APPLICANT'S RESPONSES TO RELEVANT REPRESENTATIONS AND ADDITIONAL SUBMISSIONS

Drax Bioenergy with Carbon Capture and Storage

Document Reference Number: 8.3

PINS Reference: EN010120

DRAWING TITLE
 FIGURE 18.1:
 SHORT LIST OF 'OTHER DEVELOPMENTS'
 CONSIDERED WITHIN THE CUMULATIVE
 IMPACTS ASSESSMENT
 SHEET OF 1 OF 7

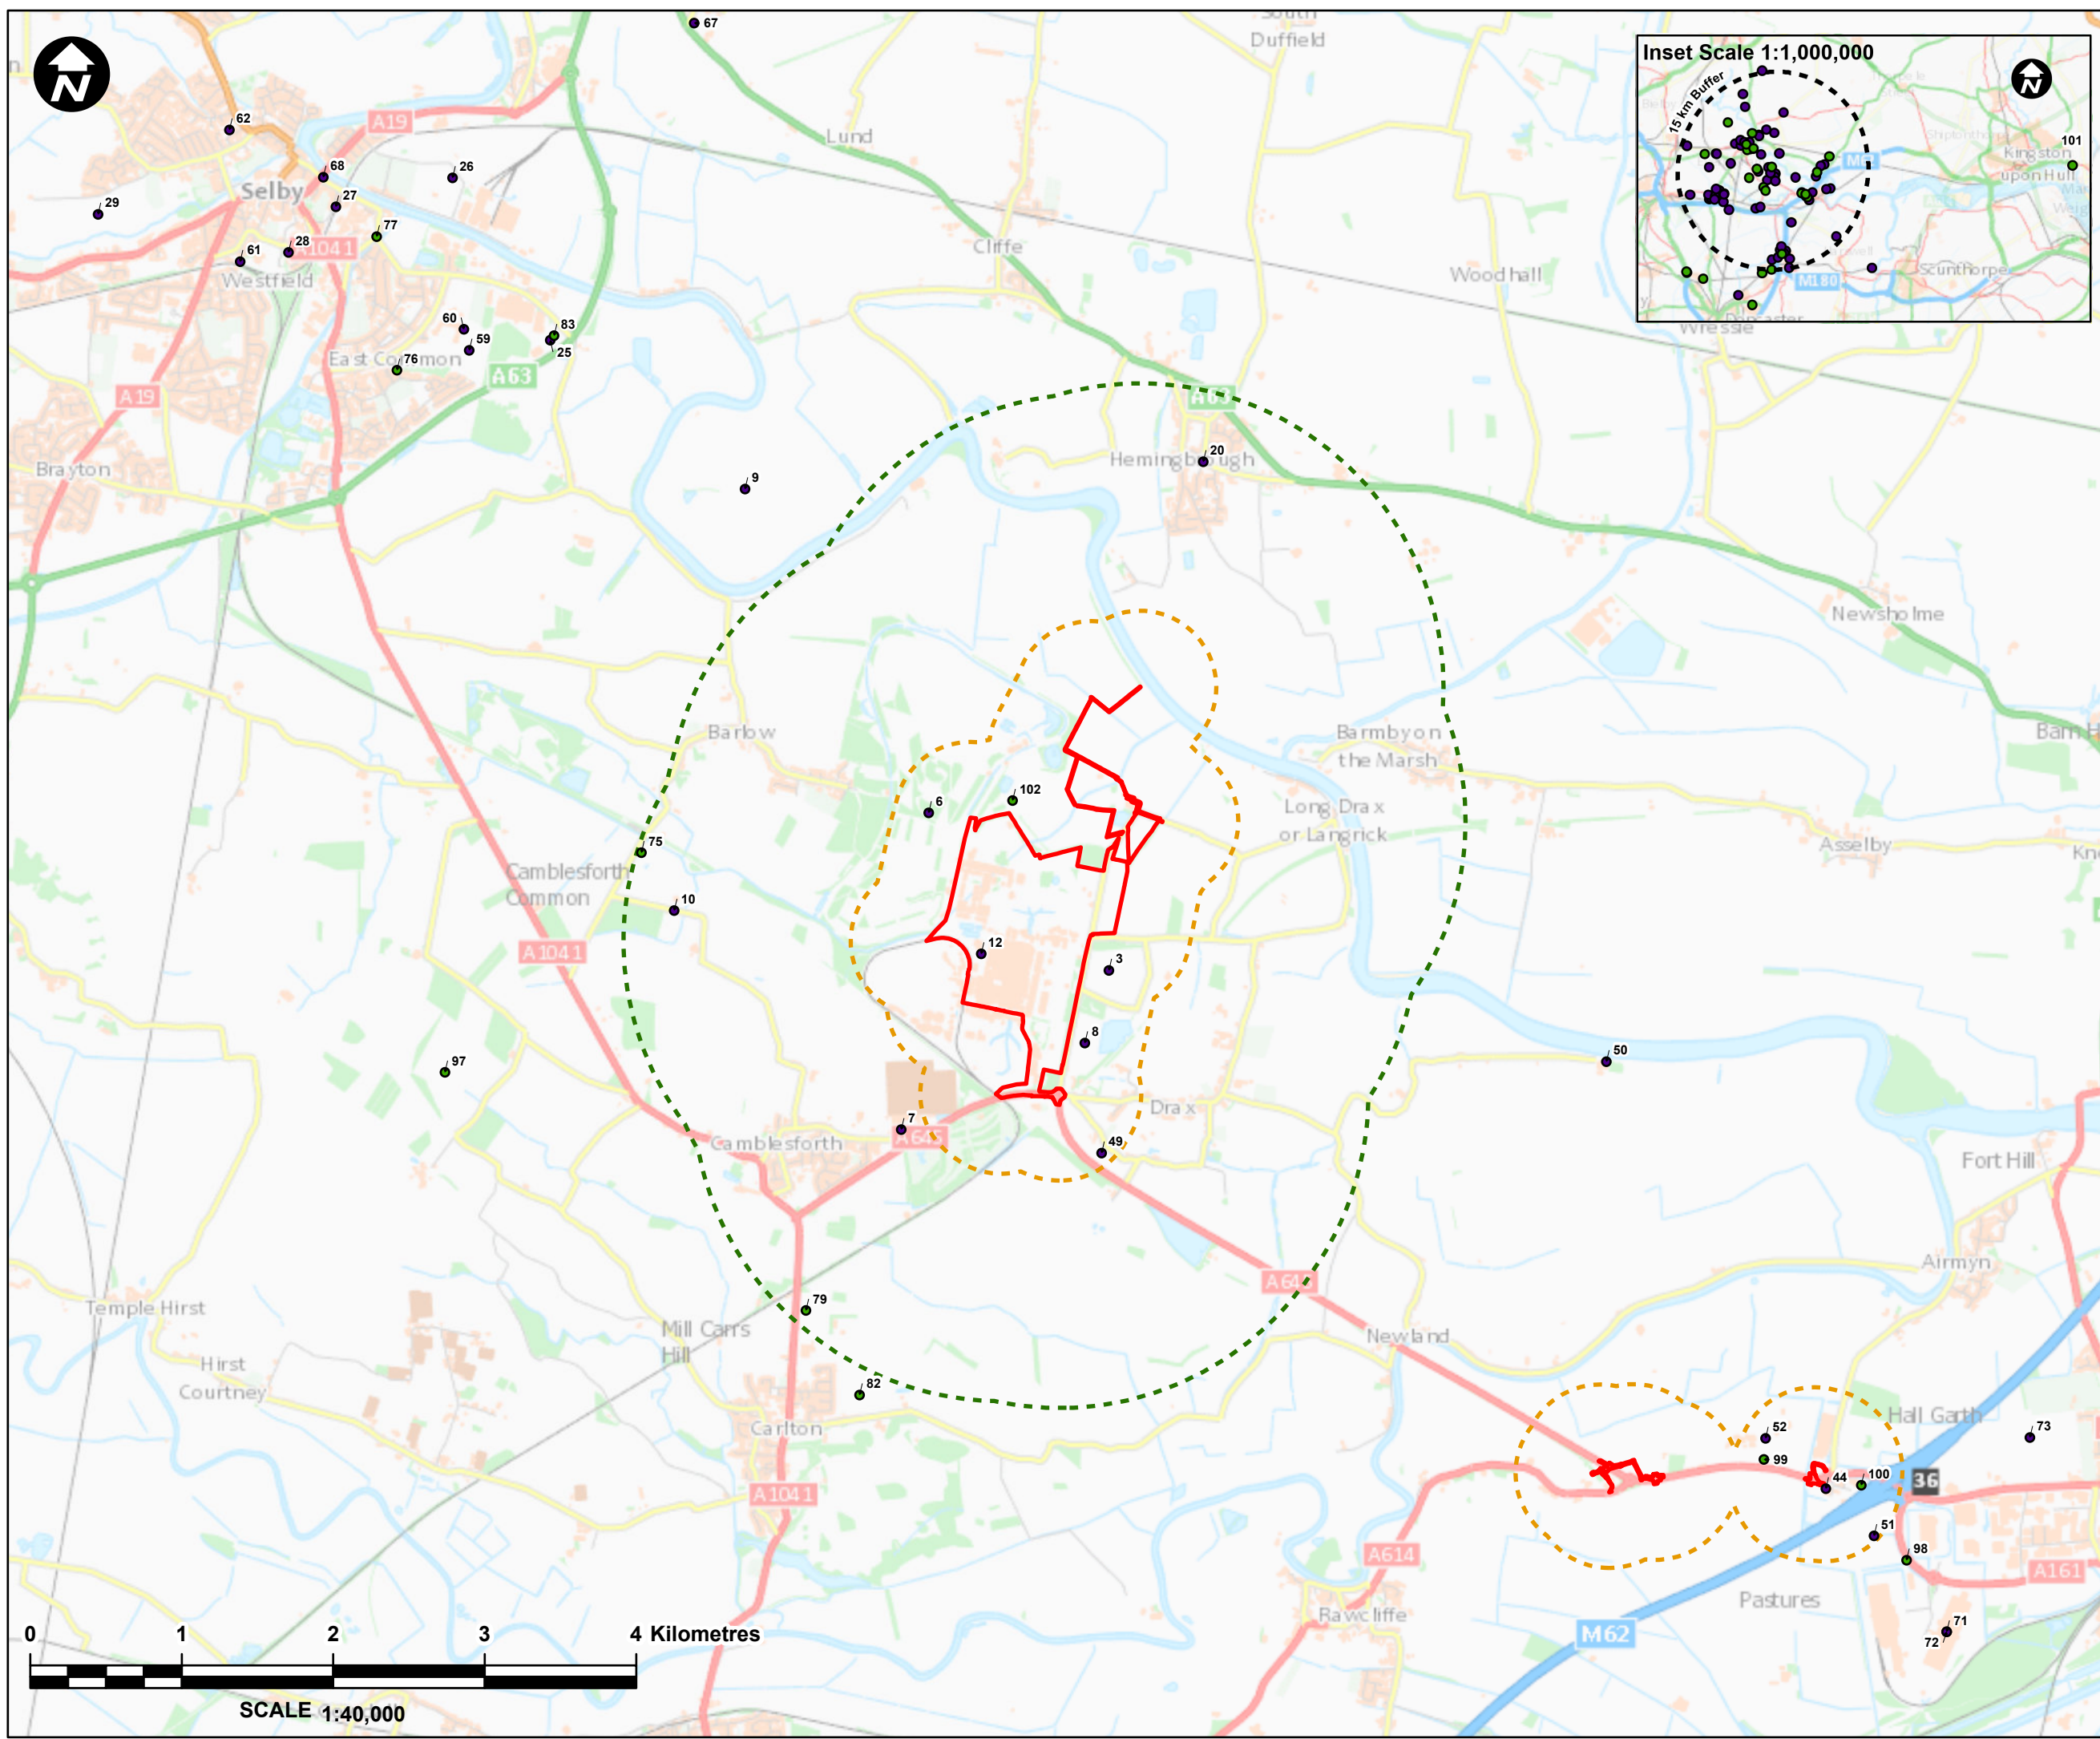
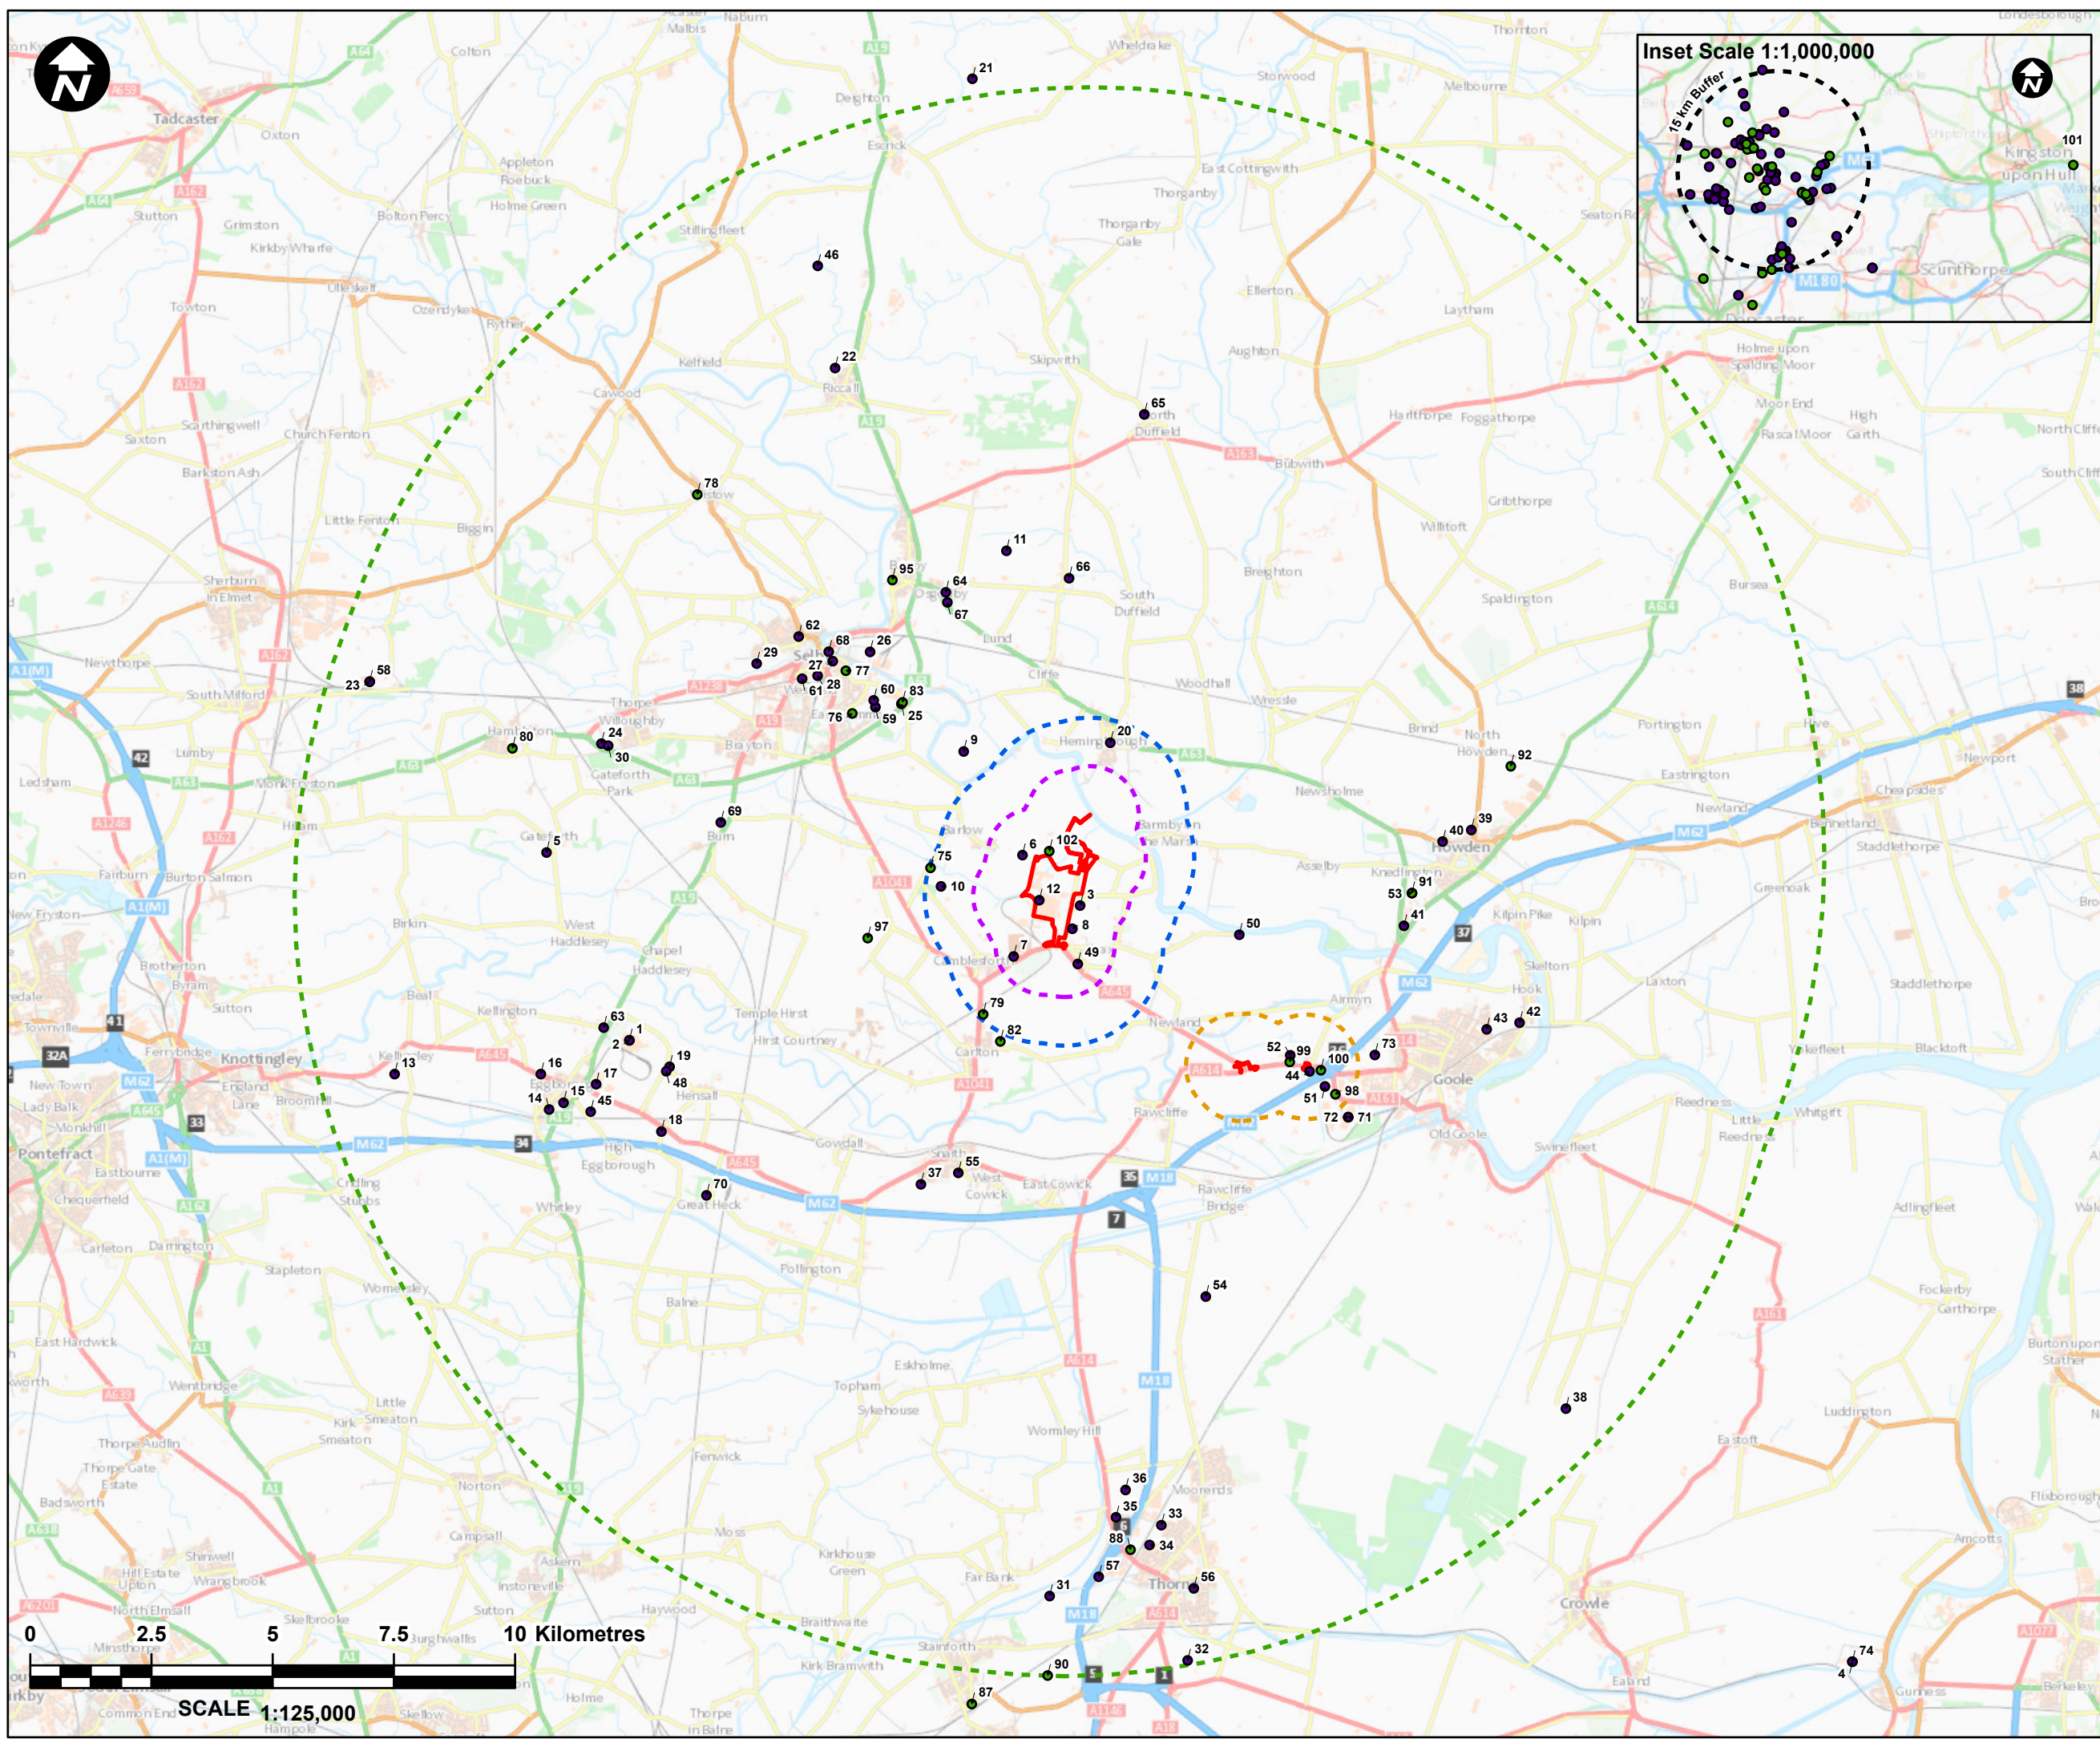
Response Ref.	Relevant Representation Comment	Applicant's Response
2.12. Cumulative	It has been noted that 6.3.18.2 Environmental Statement - Volume 3 - Appendix 18.2 'Short List of Other Developments' only contains 46 schemes, while the Environmental Statement refers to 76 schemes. It is understood that the applicant is aware of this issue and is looking to issue a corrected version for consideration.	This comment is noted and it is confirmed that the formatting error has been amended and a new version was issued to NYCC/SDC and other consultees on 1 September 2022. The updated document was reissued to PINS on 7 October 2022 (AS-013).
